CITY OF ALBUQUERQUE  
 PLANNING DEPARTMENT  
 DEVELOPMENT REVIEW BOARD

**Project# 1009506**

BOHANNAN HUSTON INC agents for PULTE HOMES OF NEW MEXICO request the referenced/ above actions for Lots 15-21, **VOLCANO CLIFFS UNIT 6 (tbka MONTECITO WEST UNIT 1)** zoned SU-2 VOLCANO CLIFFS RURAL RESIDENTIAL (VCRR), located on the west side of ALBERICOQUE PL NW between VISTA VIEJA NW and SCENIC RD NW containing approximately 29.54 acre(s). (D-9)

**PARKS & RECREATION DEPARTMENT COMMENTS Item #3**

PRELIMINARY PLAT FOR
MONTECITO WEST UNIT 1
LOTS 1 - 46 & TRACTS 1 - 8, A
CITY OF ALBUQUERQUE
BERNALILLO COUNTY, NEW MEXICO
NOVEMBER 2013

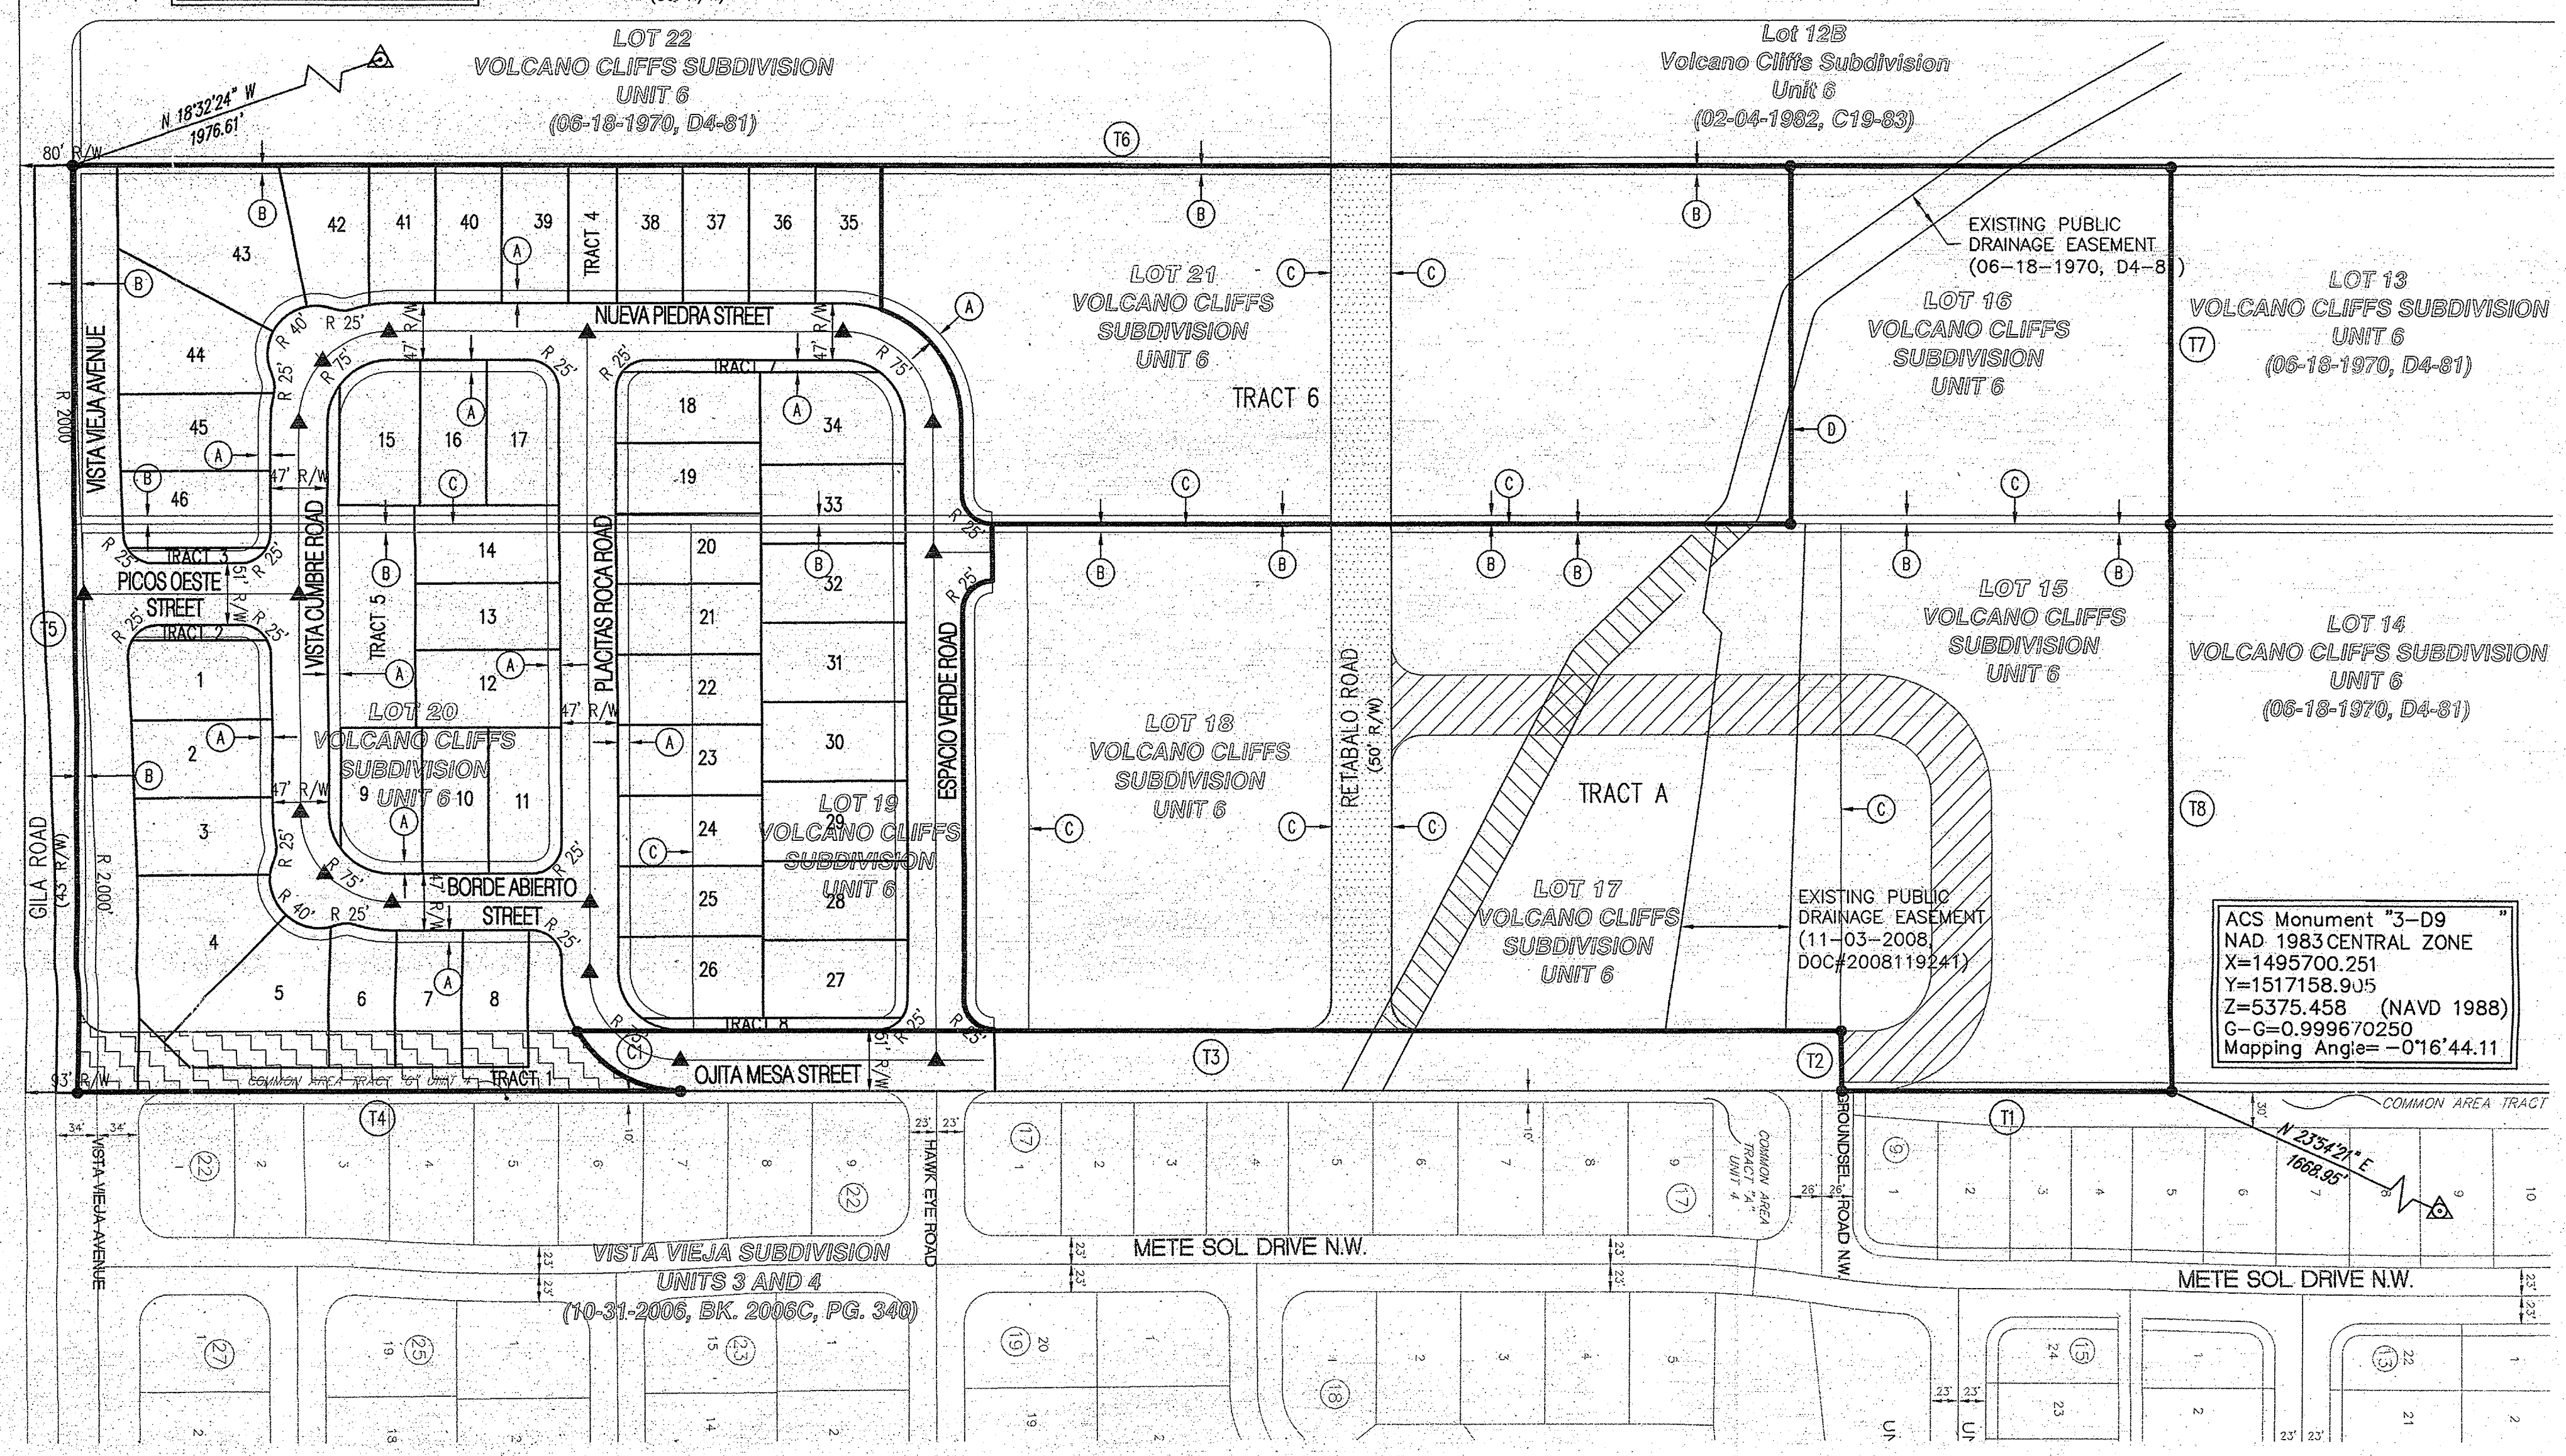
- a. The vacation texture on Tract 1 obscures the note regarding “Common Area Tract... for Unit4) and could be moved to Unit 4 of Vista Vieja so it would be legible. Tract A label on Lot 17 is confusing.

- b. Parks & Recreation’s Open Space Division requests that the Parceled Commons Areas Tracts 5 & 6 be dedicated to the City to be managed as public Open Space by the Open Space Division. Please change General Notes #7 to reflect this change.

- c. The Public Open Space will need to be fenced prior to construction of adjacent infrastructure and residential lots to prevent damage to existing vegetation.

- d. Please change all references to Private Commons Areas (PCA) as the name has been changed to Parceled Common Areas (PCA) within Private Commons Development (PCD). Per the Ordinance, Parceled Common Areas can be Public or Privately owned and maintained. In this request, the Parceled Commons Areas shall be Public Parceled Commons Areas.

- e. Legend shows "Existing fence line" but it is not shown on the Preliminary Plat as existing along the south boundary of the Unit south side of Gila Road, please show this existing fence.
- f. Provide note in General Notes as to the responsibility of the HOA to maintain the 2 HOA tracts.
- g. Line weights in the Legend are difficult to differentiate on the Plat.

SITE DEVELOPMENT PLAN FOR SUBDIVISION MONTECITO WEST UNIT 1

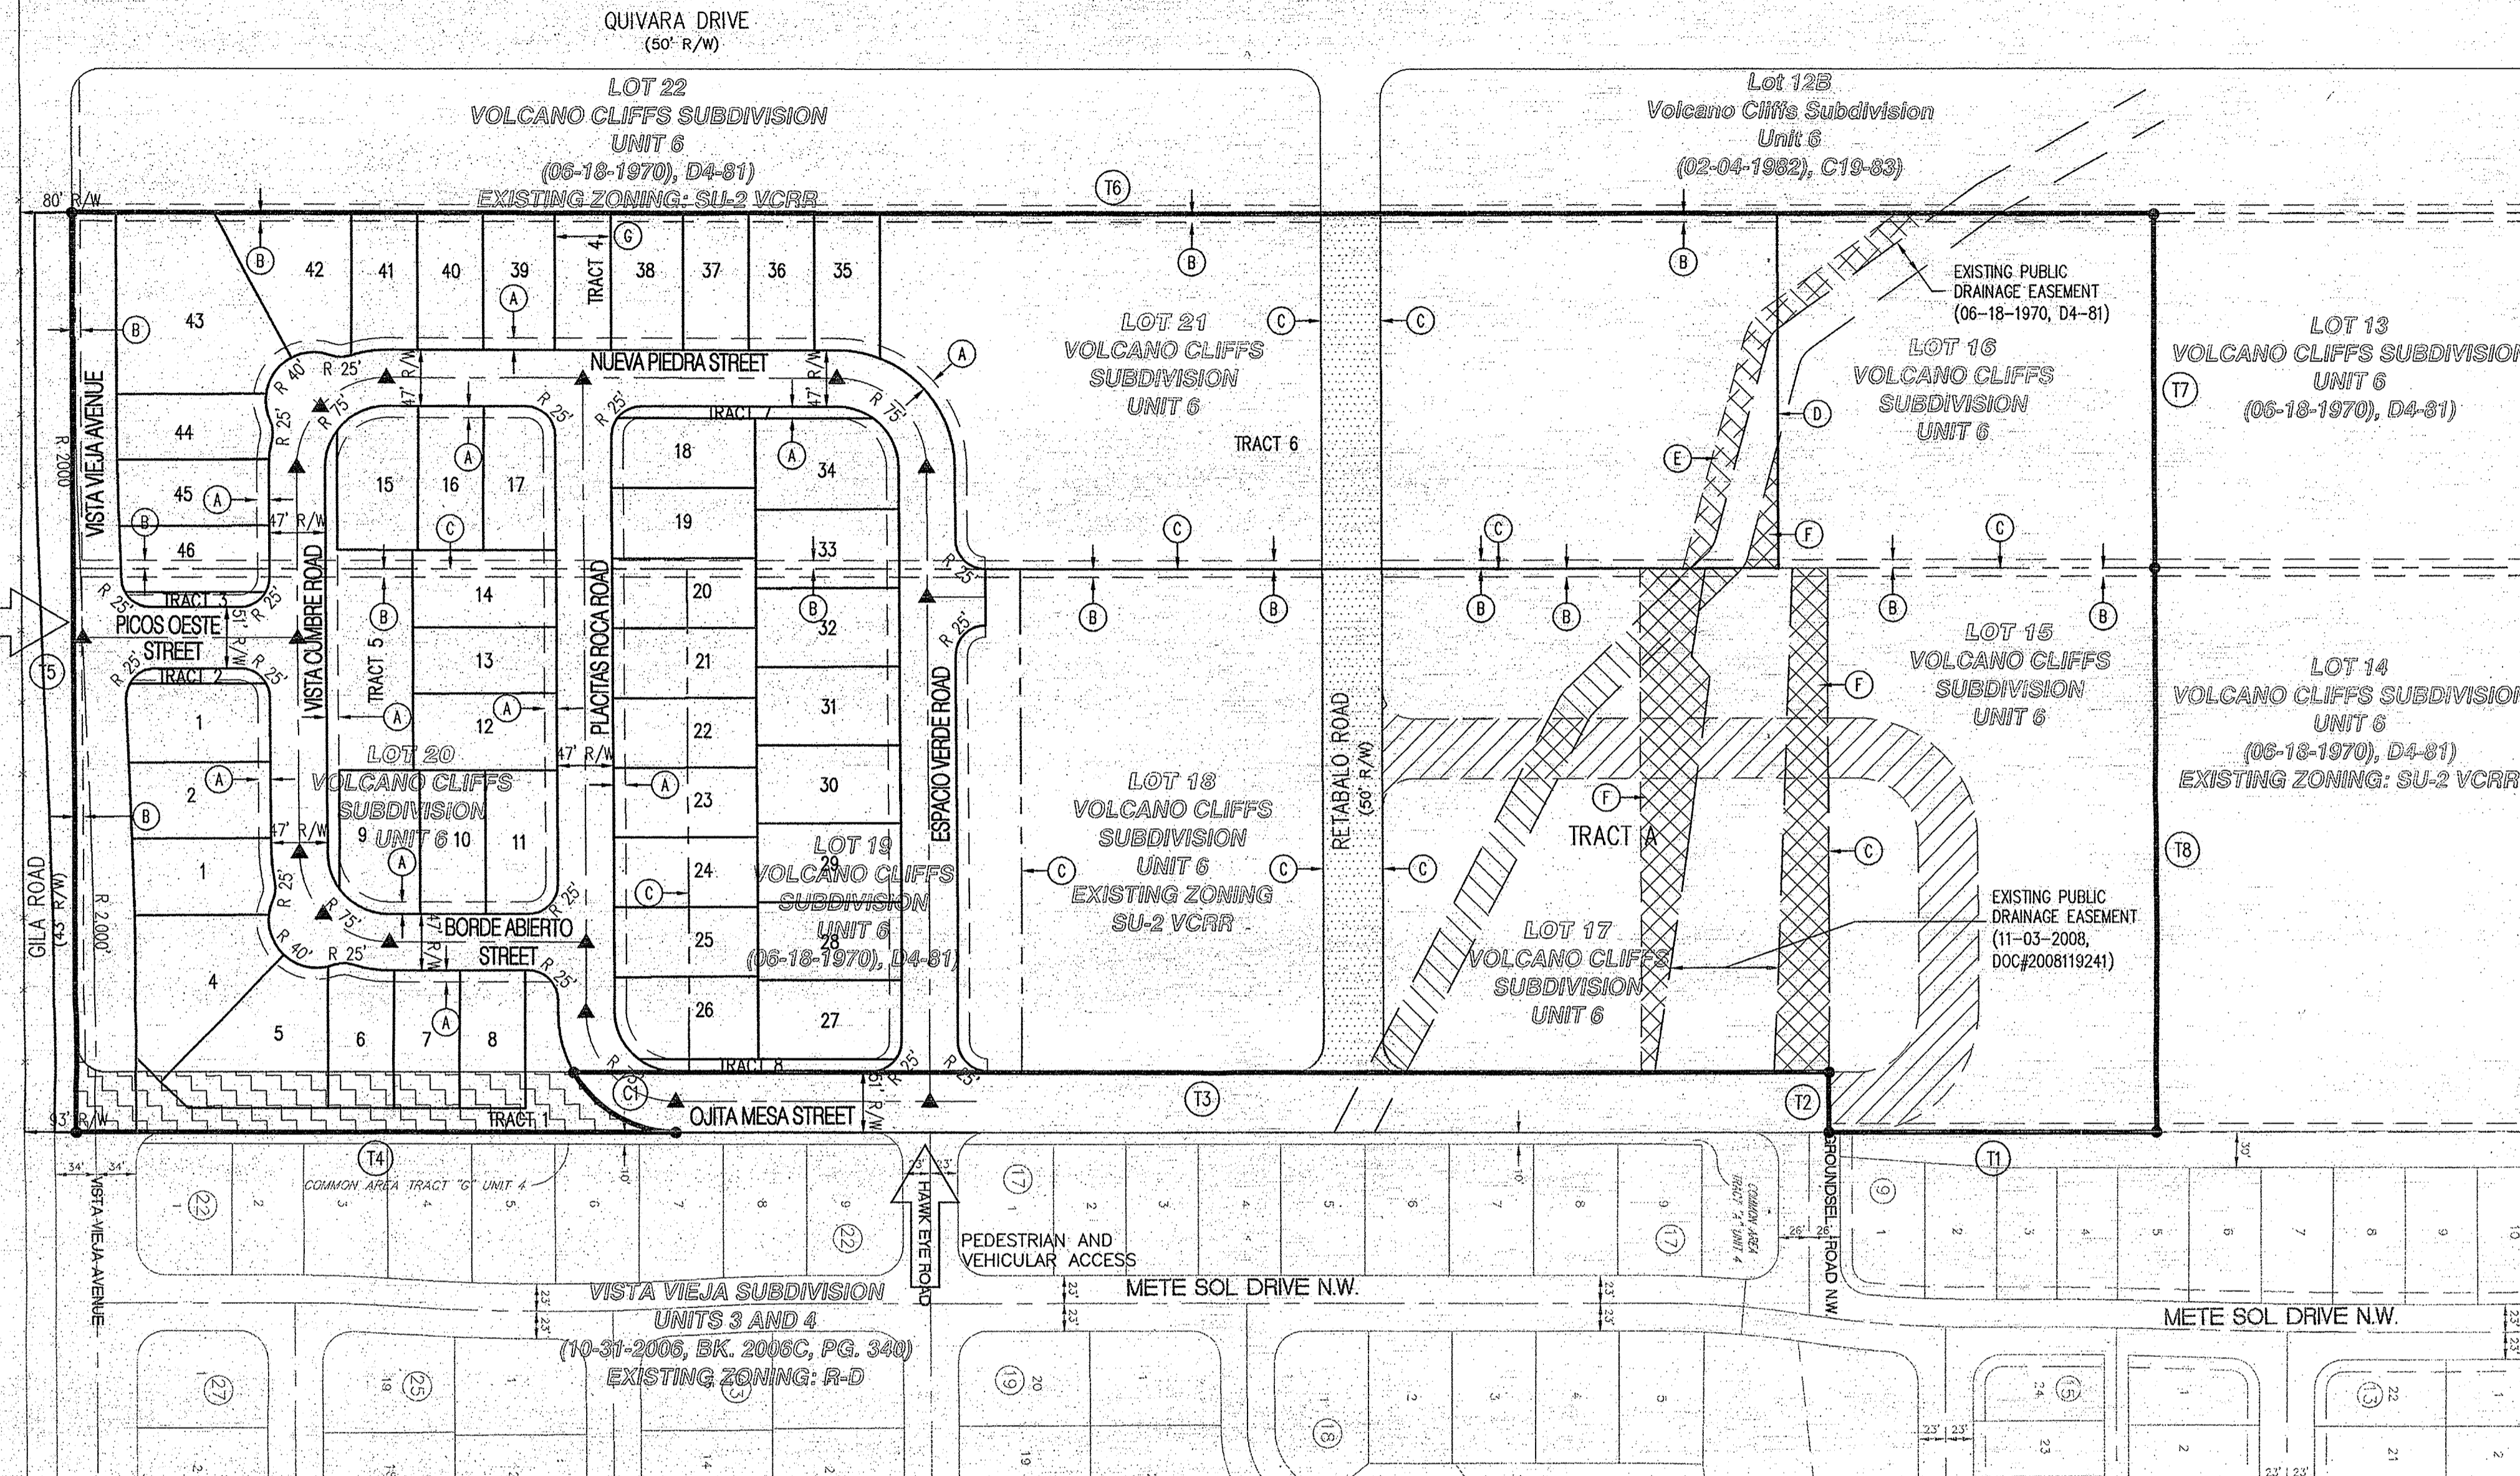
- a. More information is needed regarding the 6 HOA tracts, the 2 Private Common Area tracts and the one Remainder Tract so that the differences are clear on the SPSD. The vacation texture on Tract 1 obscures the note regarding “Common Area Tract... for Unit4) and could be moved to Unit 4 of Vista Vieja so it would be legible. Tract A label on Lot 17 is confusing.

- b. Parks & Recreation’s Open Space Division requests that the Parceled Commons Areas Tracts 5 & 6 be dedicated to the City to be managed as public Open Space by the Open Space Division. Please change General Notes #7 to reflect this change.

- c. The Public Open Space will need to be fenced w/open space fencing prior to construction of adjacent infrastructure and residential lots to prevent damage to existing vegetation. Fencing to be added to Infrastructure List.

- d. Please change all references to Private Commons Areas (PCA) as the name has been changed to Parceled Common Areas (PCA) within Private Commons Development (PCD). Per the Ordinance, Parceled Common Areas can be Public or Privately owned and maintained. In this request, the Parceled Commons Areas shall be Public Parceled Commons Areas.

- e. Legend shows “Existing fence line” but it is not shown on the Preliminary Plat as existing along the south boundary of the Unit south side of Gila Road, please show this existing fence.

- f. Provide note in General Notes as to the responsibility of the HOA to maintain the 6 HOA tracts.
- g. Line weights in the Legend are difficult to differentiate on the Plat.
